Development Review Board 10/10/07 Agenda Item #17
Sketch Plat: Lots 5, 6, 7, & 8, Raynold's Addition

DEVELOPMENT REVIEW BOARD – SPEED MEMO

DRB CASE NO/PROJECT NO: 1006853

RE: Lots 5-8, Block 54, Raynolds Addition/sketch

SKETCH PLAT OF LOTS A, B, C, D & E IRON AVENUE TOWNHOMES

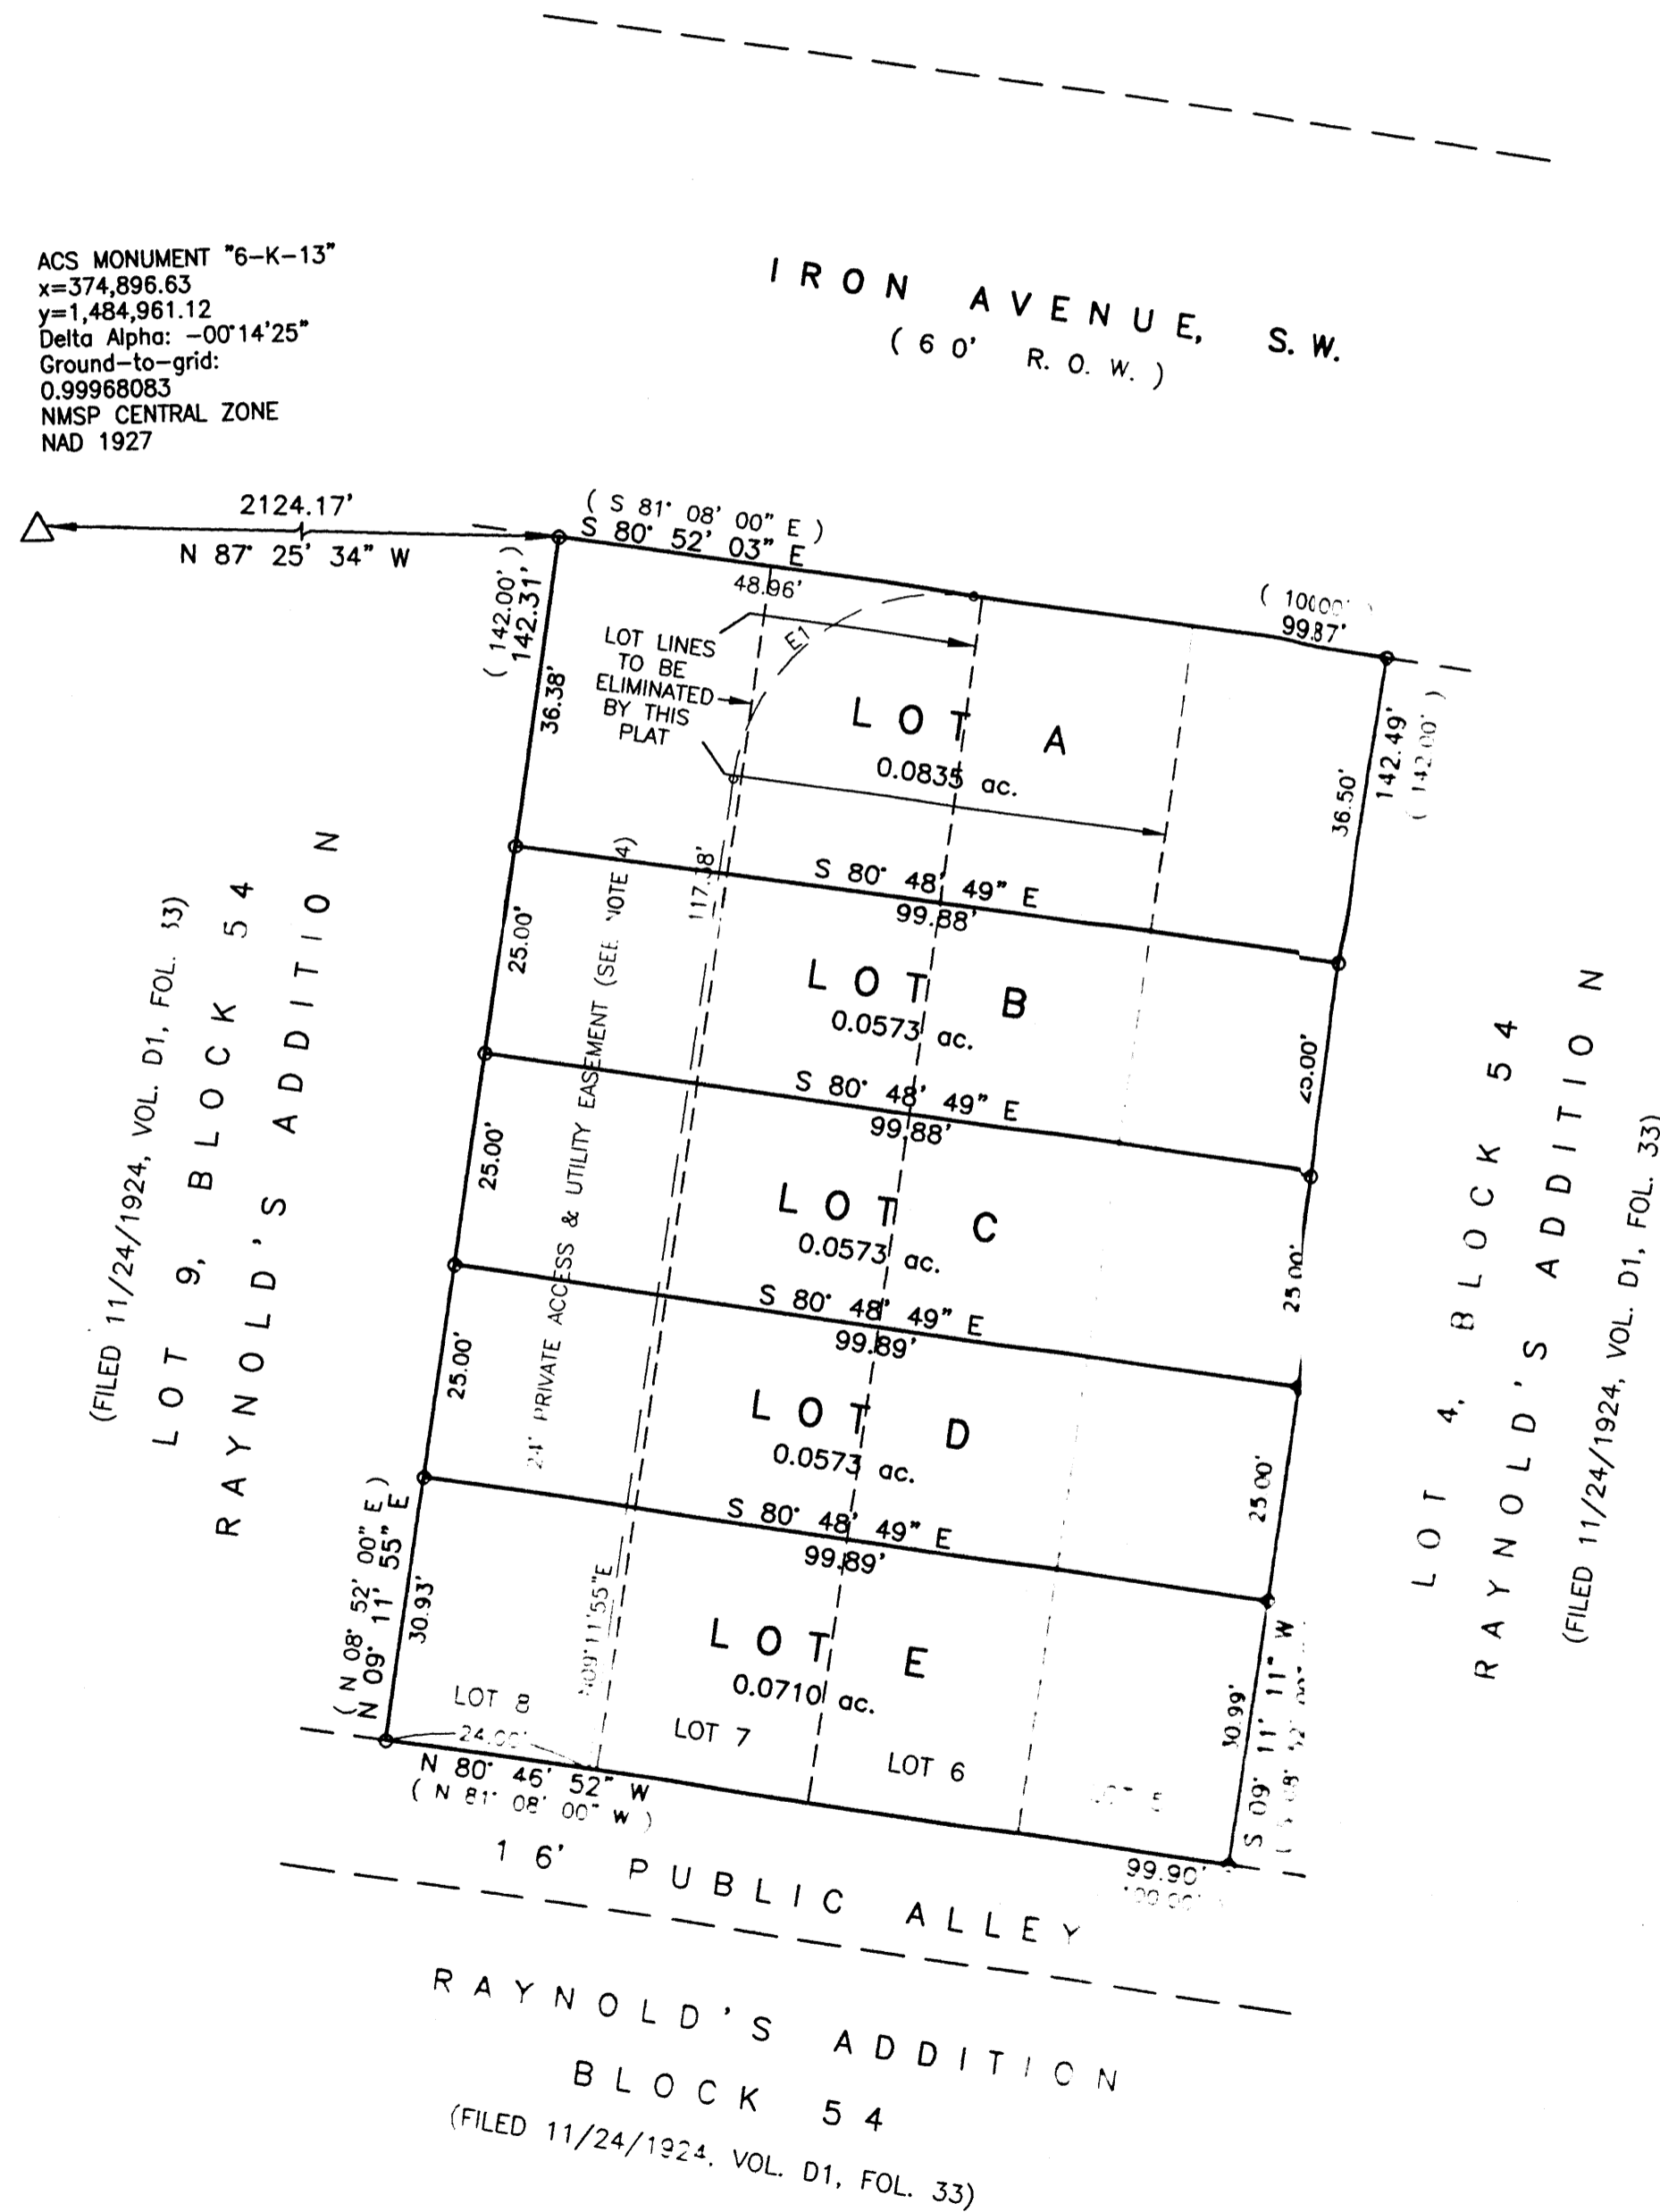
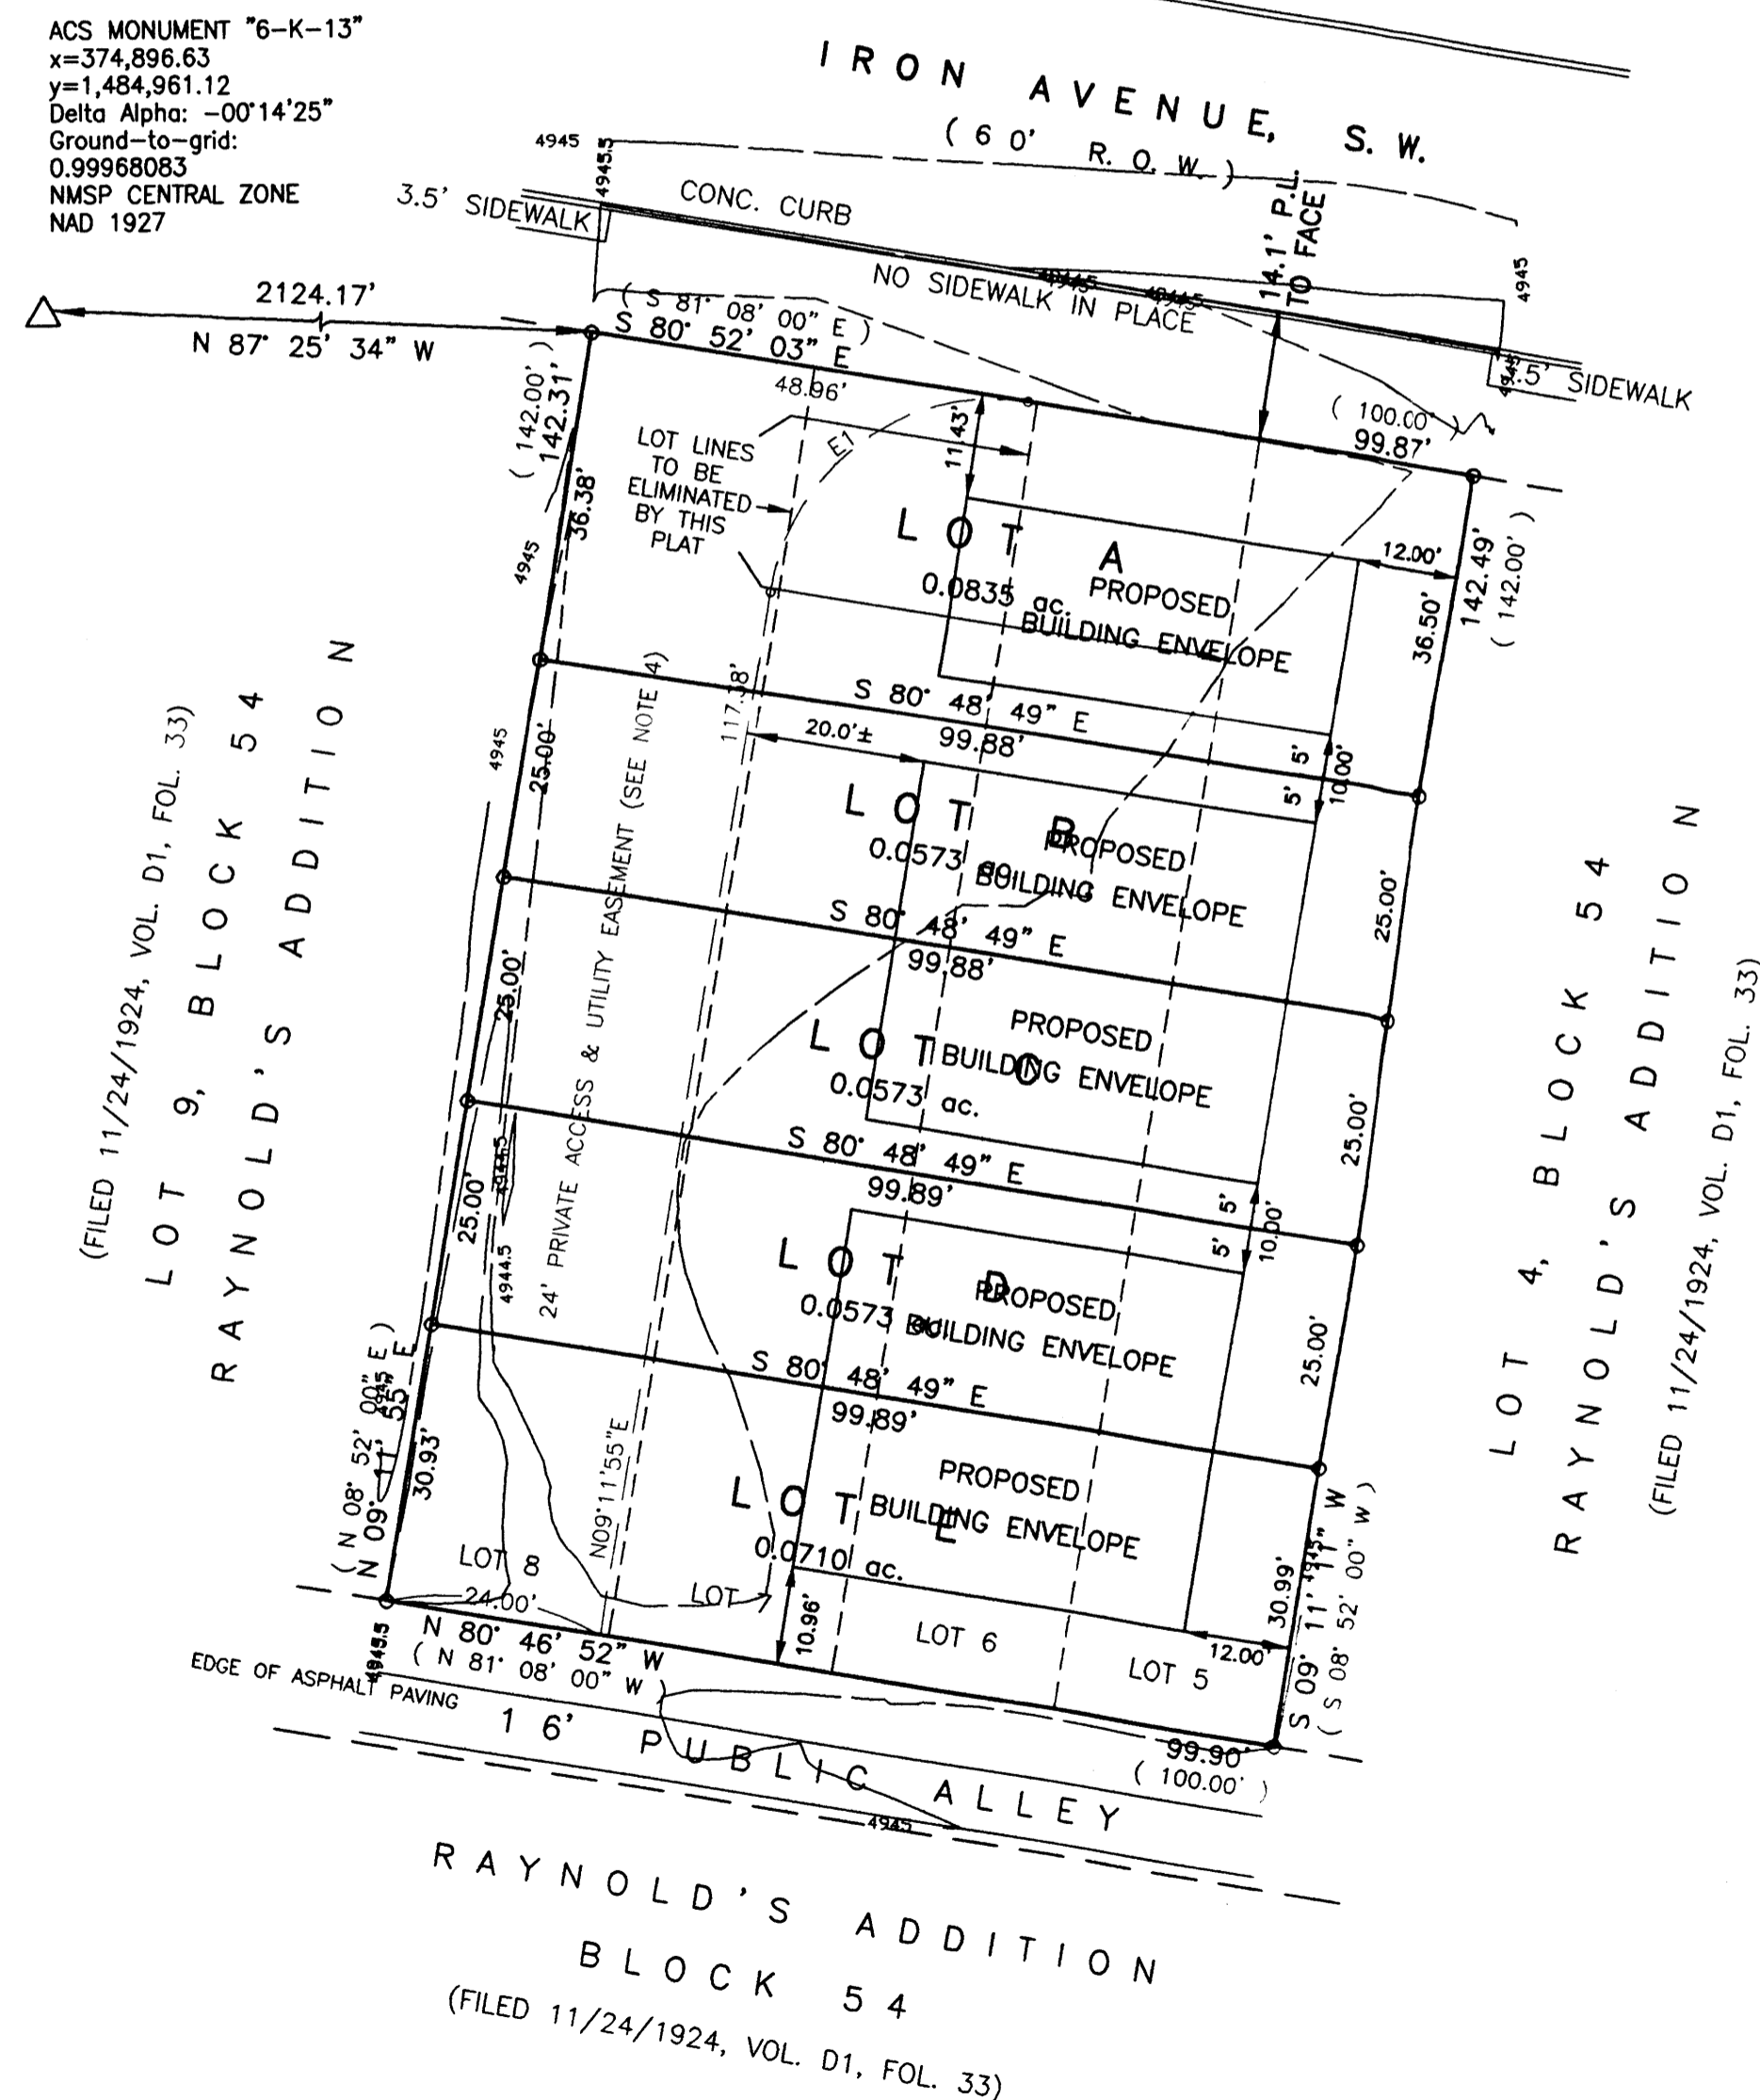
An approved infrastructure list is required for Preliminary Plat approval.
An approved drainage report must be on file prior to Preliminary Plat approval.

No.	Comment
1.	STANDARD Street improvements are required on an infrastructure list.
2.	Streets need to meet DPM criteria.
3.	R/W dedication required for alleys.
